Our Ref: EN010147

Application by Photovolt Development Partners (PVDP) on behalf of SolarFive Ltd for an Order Granting Development Consent for the Botley West Solar Farm

Advice following issue of decision to accept the application for examination

**Operational Development Plan
Central Site Area 1 of 4**

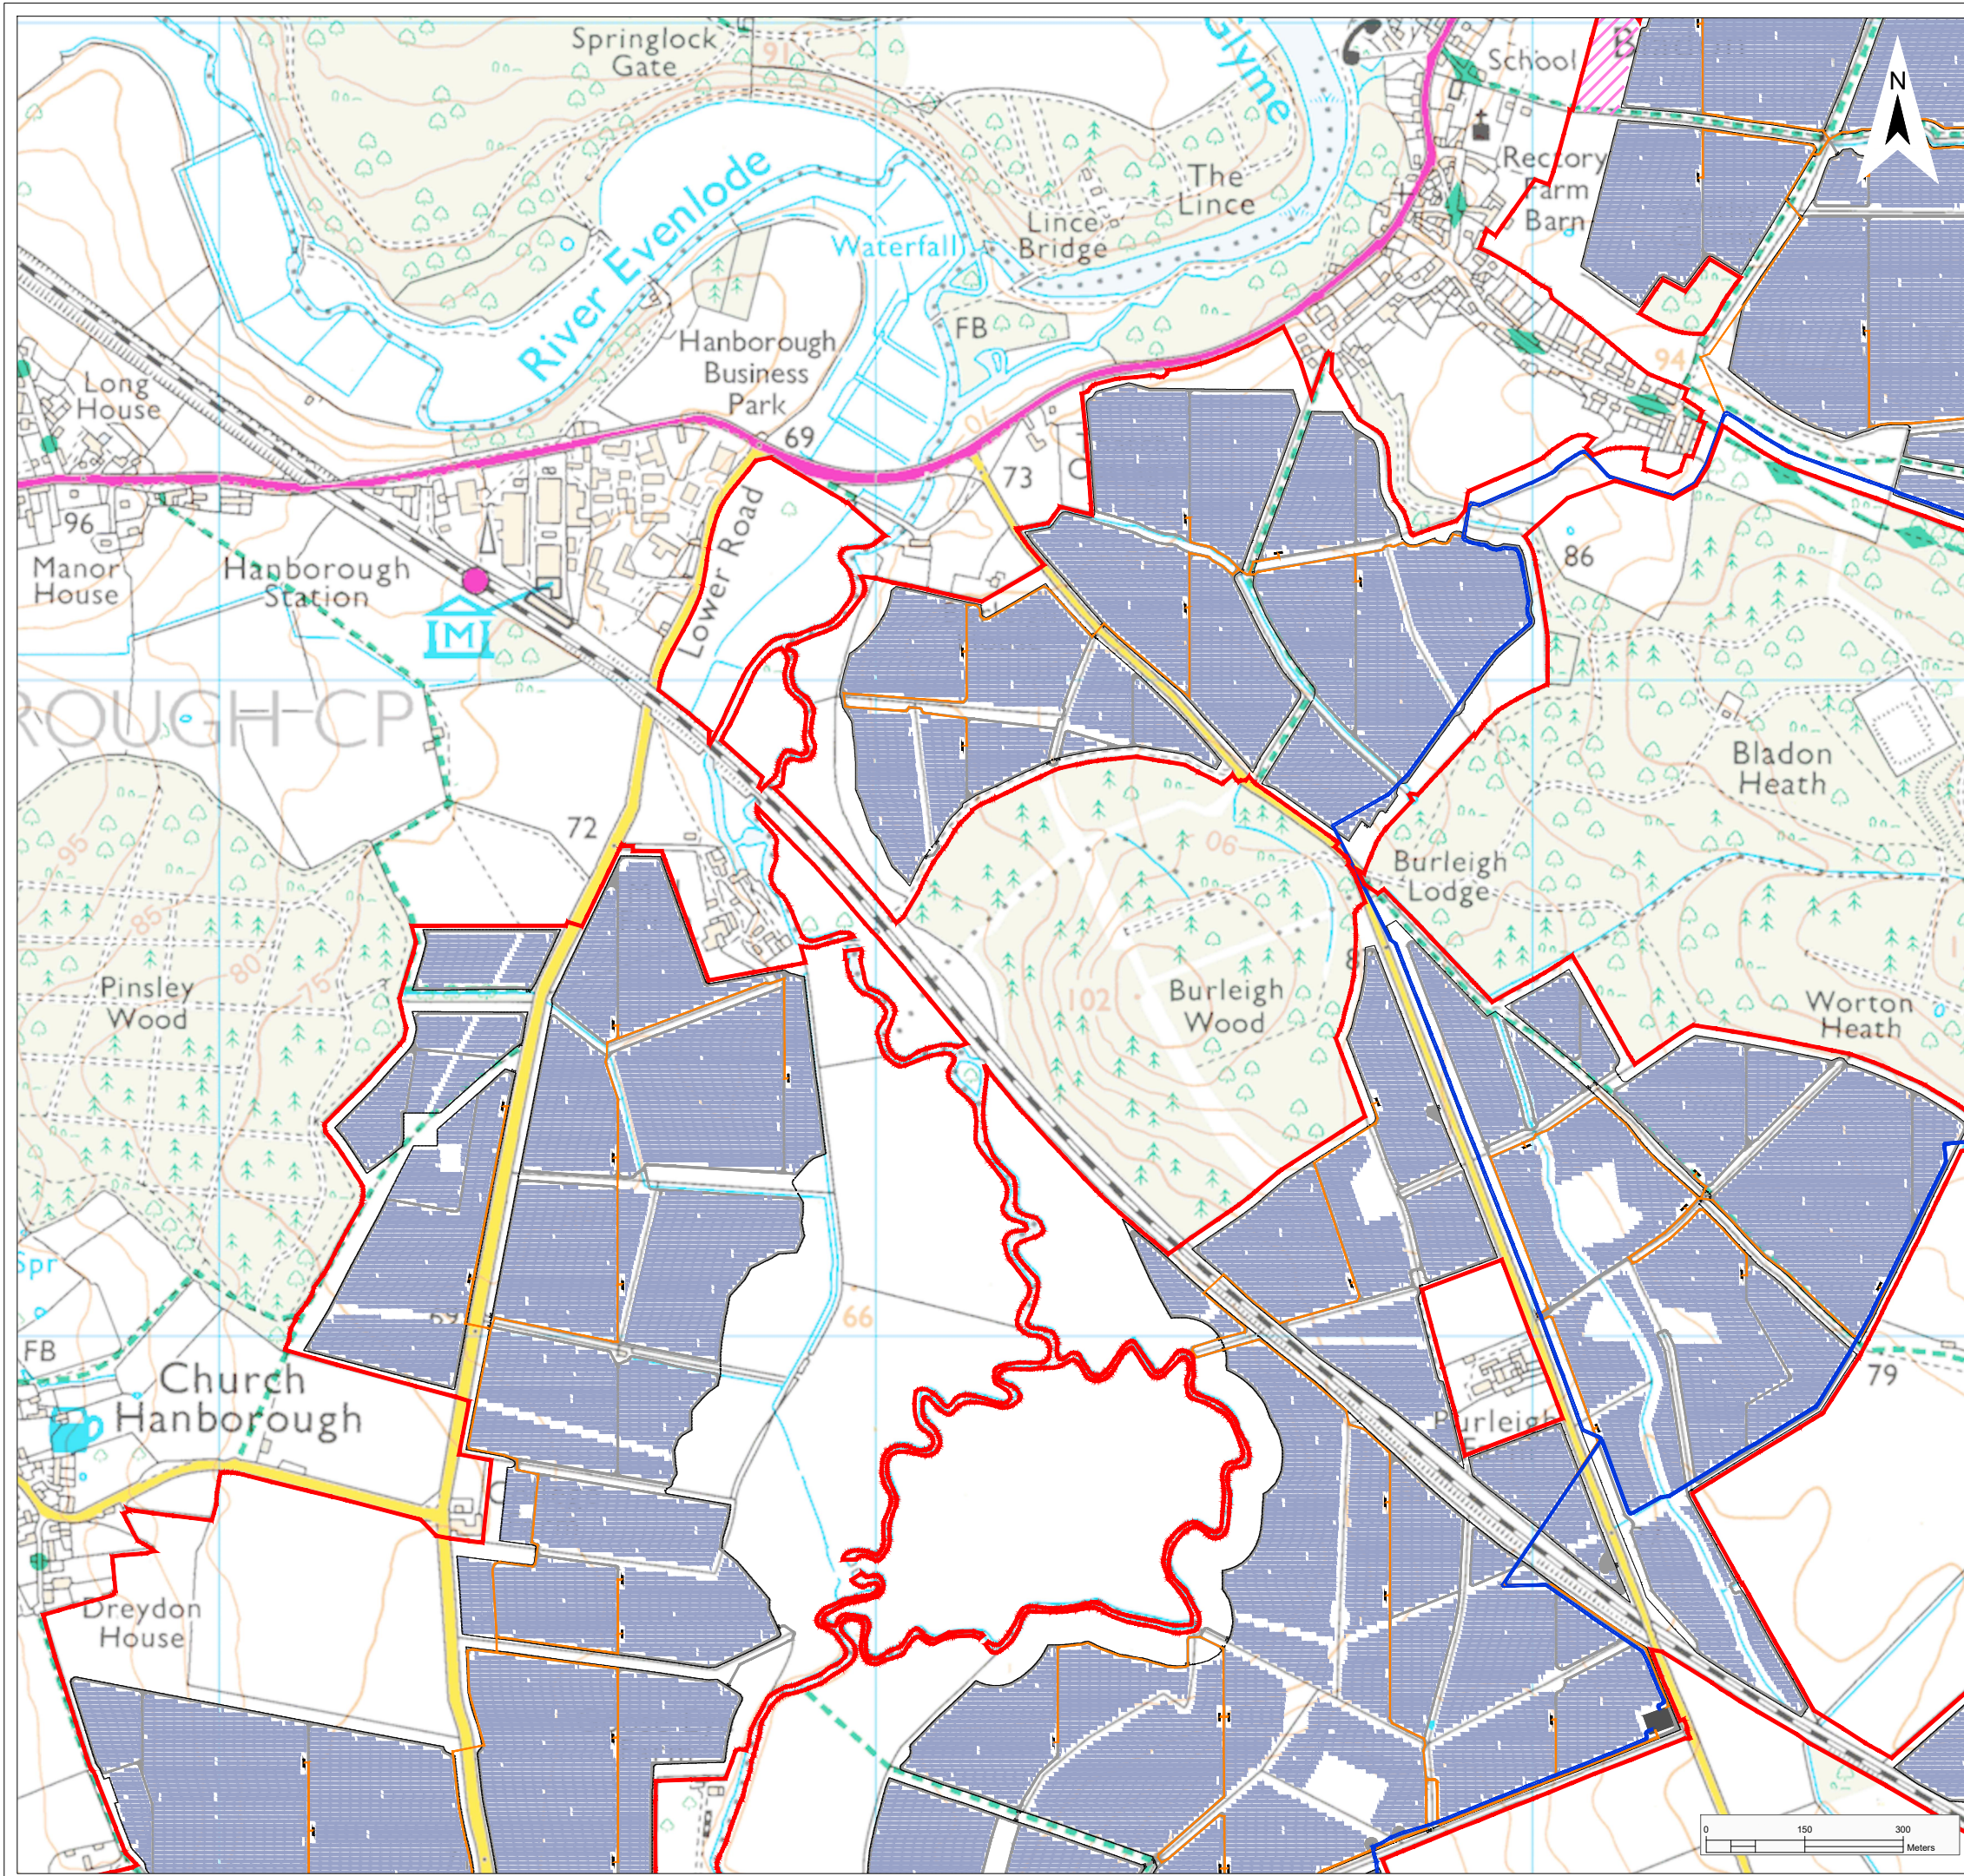
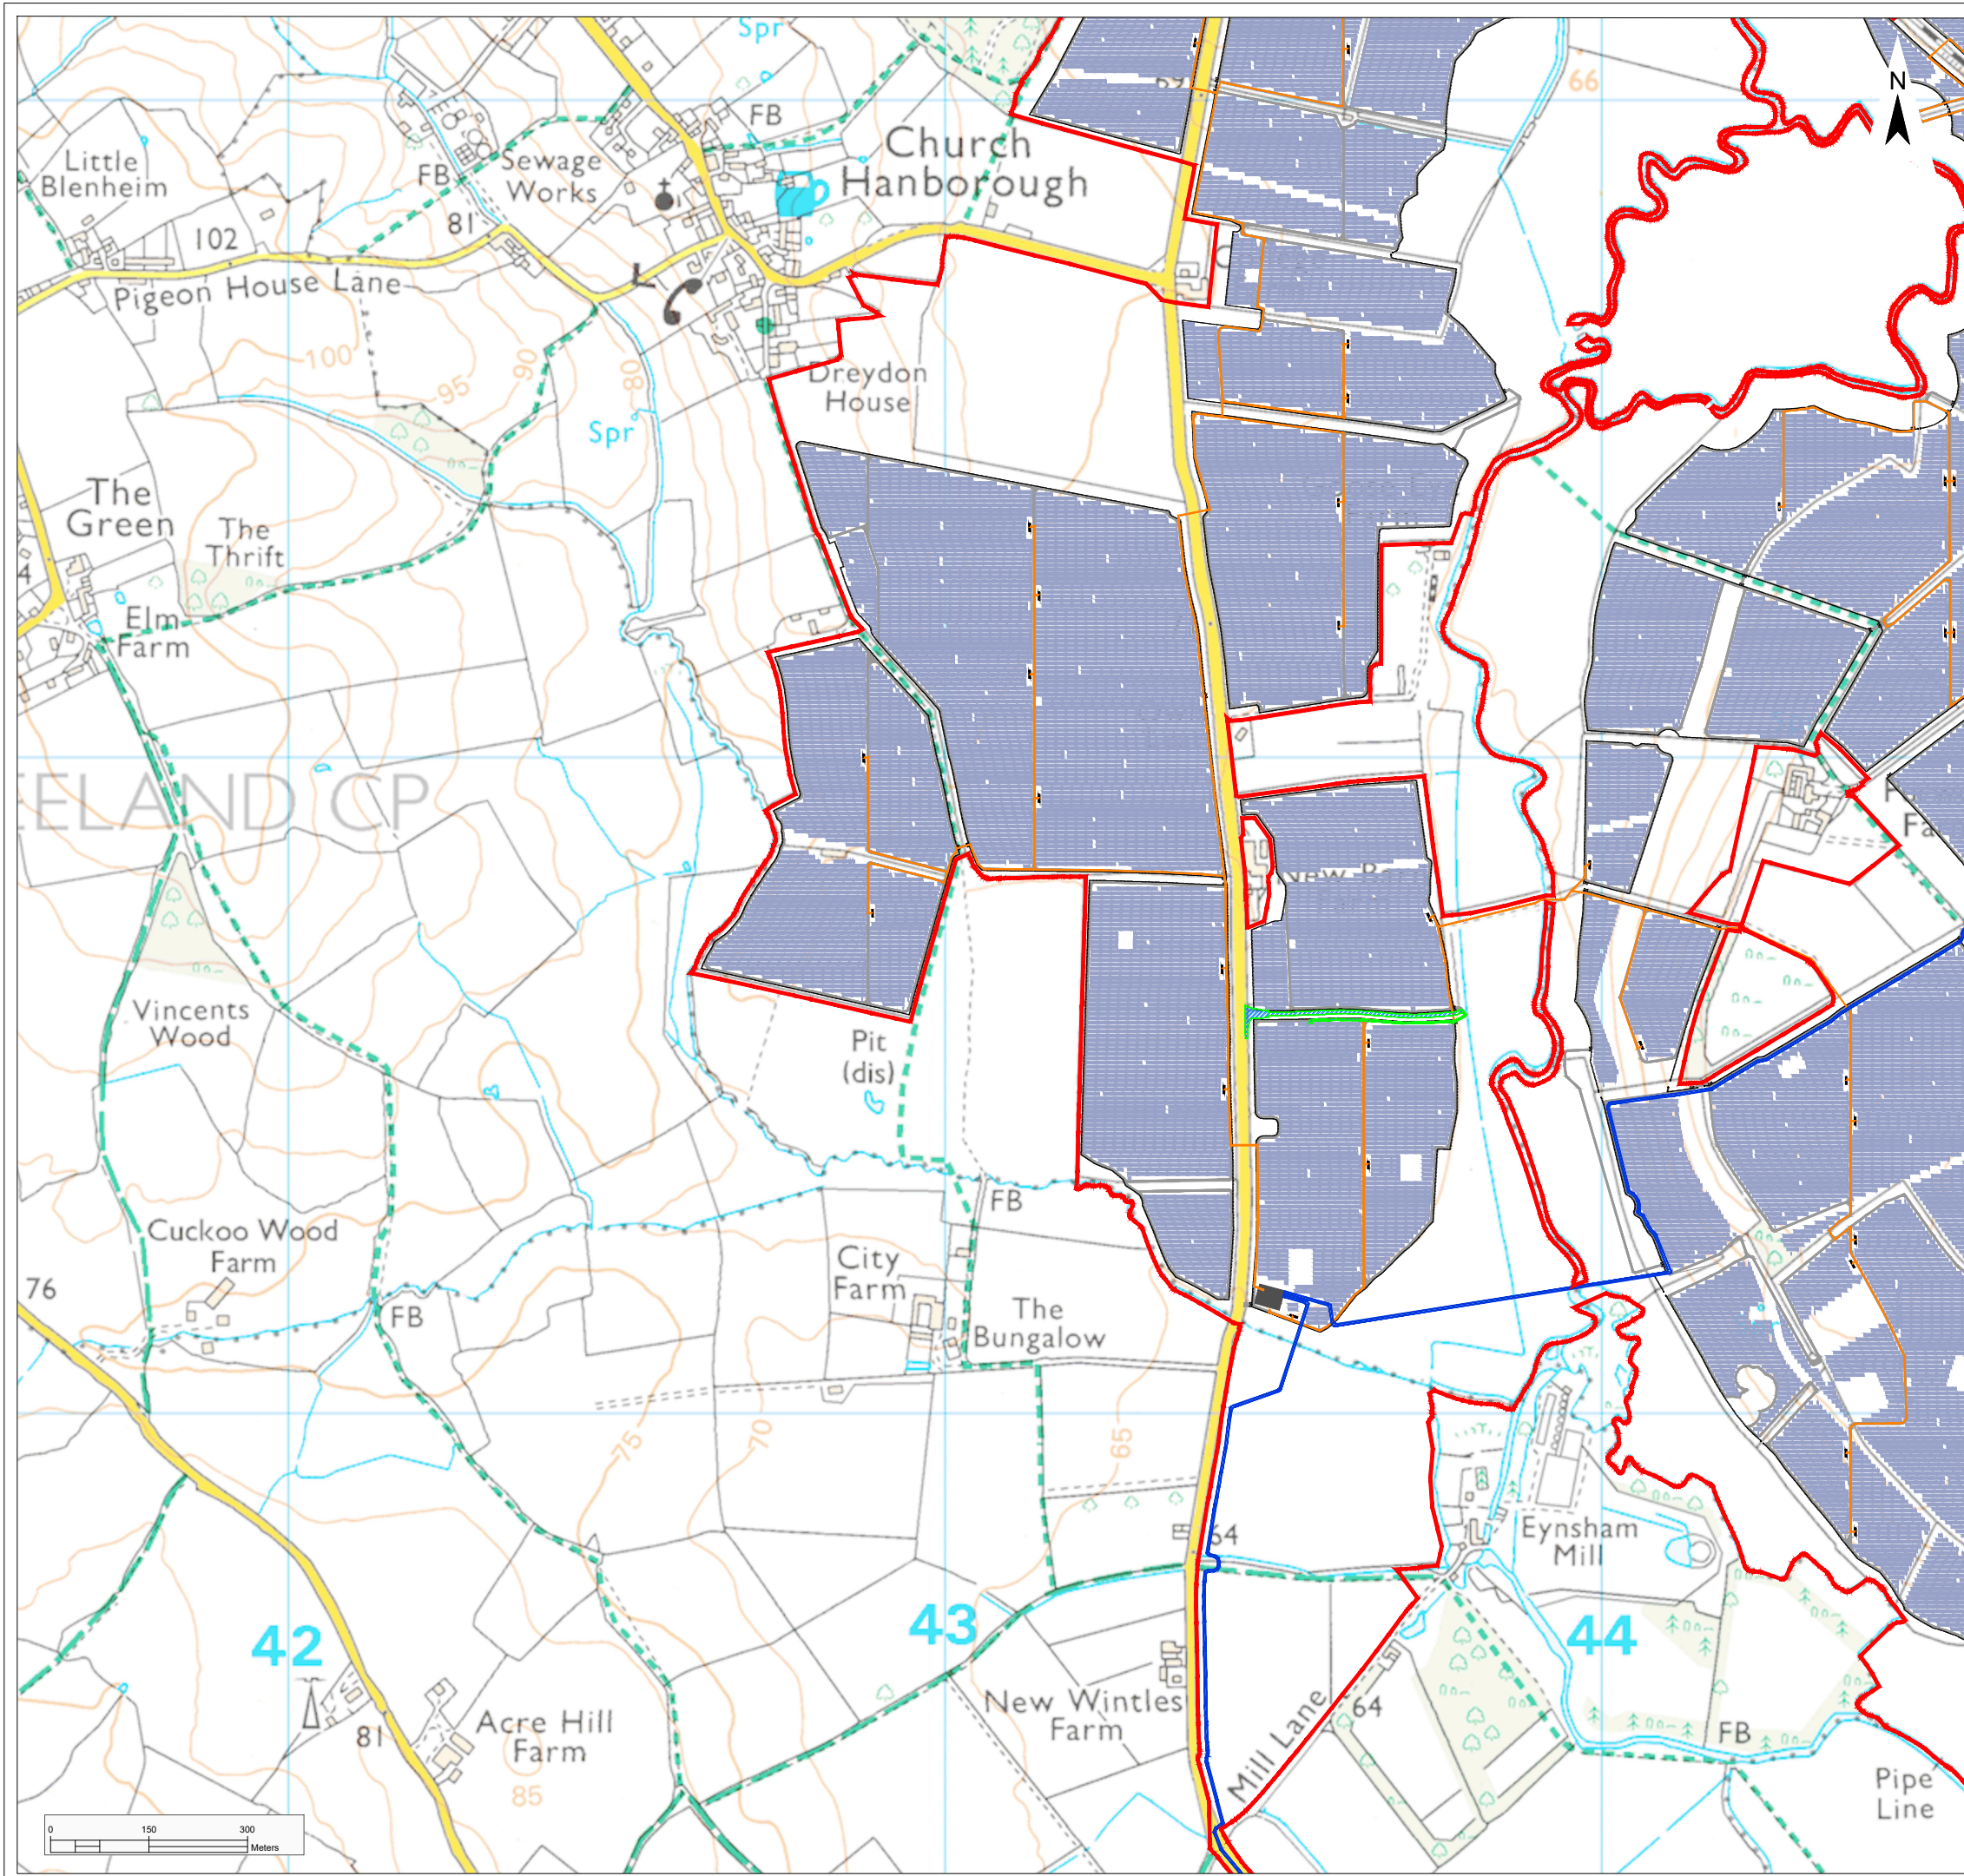
Operational Development Areas Plans (Doc 7.3.2), Landscape, Ecology & Amenities Layer Plan (Doc 7.3.3) and Temporary Facilities Plans (Doc 7.3.4)

The Inspectorate draws the attention of the applicant to APFP Regulation 5 (4A) in relation to these plan documents. The applicant may wish to amend these plans to ensure that the scale being used follows this regulation. For the benefit of the understanding of all parties to a future examination it may be desirable if it was more clearly presented on the plans which areas are within the Order Limits and how the sheet in question fits in the context of the wider site.
